WEST SUSSEX COUNTY COUNCIL CONSULTATION

TO:	Arun District Council FAO: J Baeza
FROM:	Highways, WSCC
DATE:	18 th May 2018
LOCATION:	Former Lanes End House Adjacent to, West Walberton Lane & Arundel Lane, Walberton, West Sussex, BN18 0QS
SUBJECT:	WA/26/18/OUT Outline application with all matters for 6 No detached houses with detached garages. This application is a Departure from the Development Plan.
RECOMMENDATION:	
S106 CONTRIBUTION TOTAL:	£N/A

Former Lanes End - Six Six bedroom detached Houses with Garages Proposed Layout Scale 1:100 @ A3 (c) PJ Developments LTD 2018		REVISIONS		01
		MM/DD/YY	REMARKS	
	1	--/--/--	...	A
	2	--/--/--	...	
	3	--/--/--	...	
	4	--/--/--	...	
	5	--/--/--	...	
West Walberton Lane Proposal

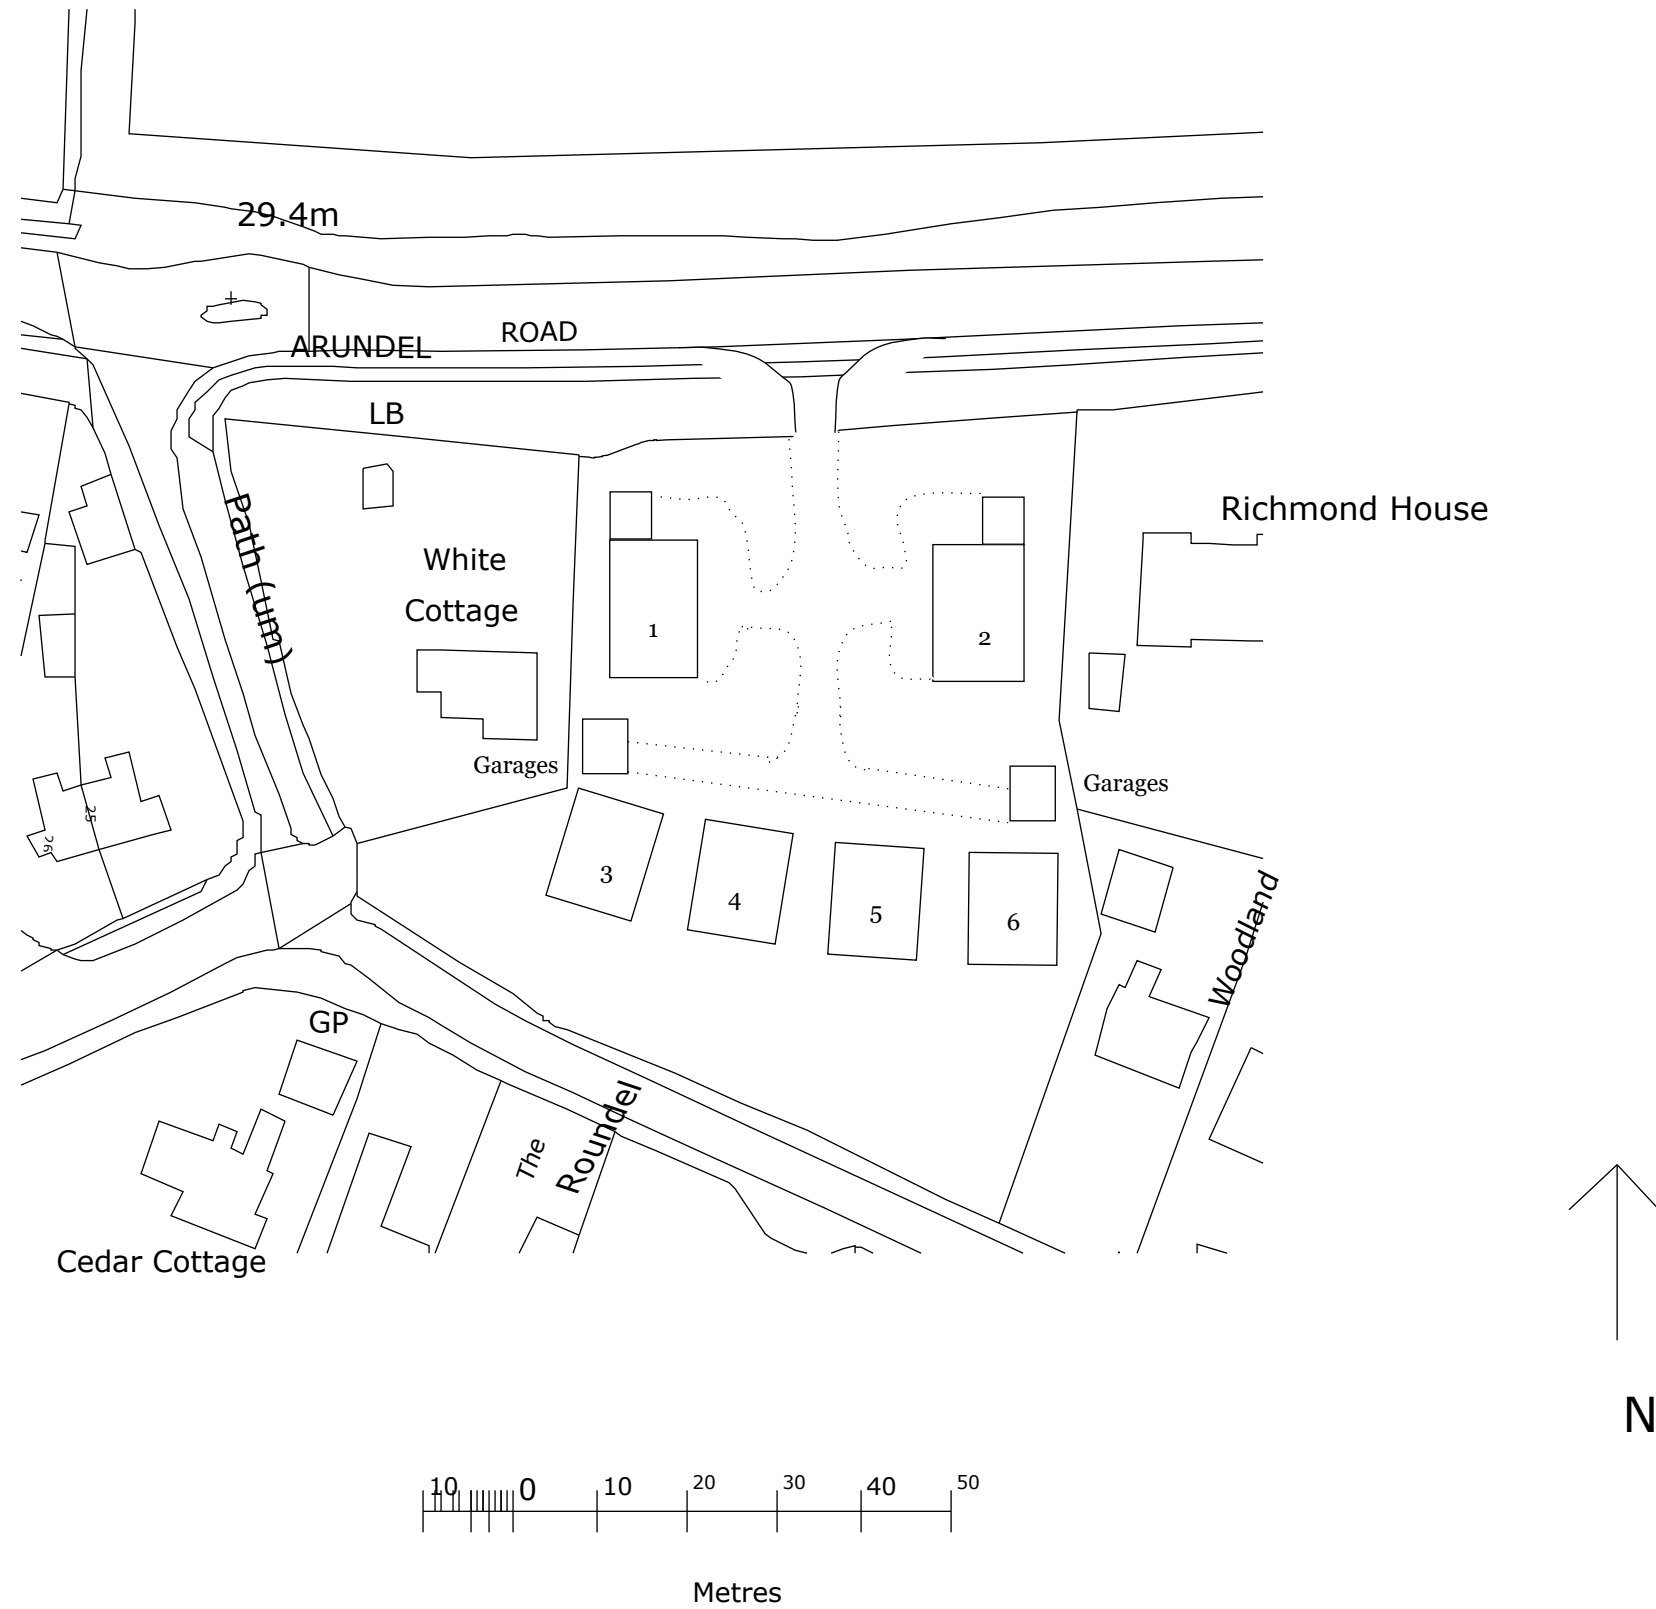
The indicative plans demonstrate a new shared access point from Arundel Road. This should be hardbound material to prevent gravel overspill to the public highway and a width of 4.8m to allow two cars to pass in the entrance. Demonstration of suitable access for Fire Appliance and Refuse Collection vehicles would be expected at reserved matters stage.

Plot 1 and 2 each appear to have their own garage with two garage buildings provided to the east and west of plots 3-6. At this stage the number of bedrooms and habitable rooms is unknown and the LHA are unable to carry out an assessment of the proposed parking provision. The applicant should ensure that details of parking provision and layout are provided at reserved matters stage. External car parking spaces should measure a minimum of 2.4m by 4.8m and single garage spaces should measure 3m by 6m in order to be counted toward parking provision. The indicative plan appears to show sufficient space for a turn on site so that cars can exit on to Arundel Road in a forward gear. Again, this should be demonstrated at reserved matters stage along with suitable access and turning facilities for refuse collection and fire appliance access.

In summary the LHA do not consider that the principle of residential development with a new access point in this location would be detrimental to the safe operation of the nearby publically maintained road network and the proposals are therefore in line with paragraph 32 of the National Planning Policy Framework. We would require details on the following as part of a reserved matters application:

- Proposed access works including width, geometry and demonstration of suitable for all vehicles.
- Proposed parking provision and layout including suitably sized parking spaces.
- Clarification on proposed refuse collection and fire appliance access including swept path tracking where appropriate.
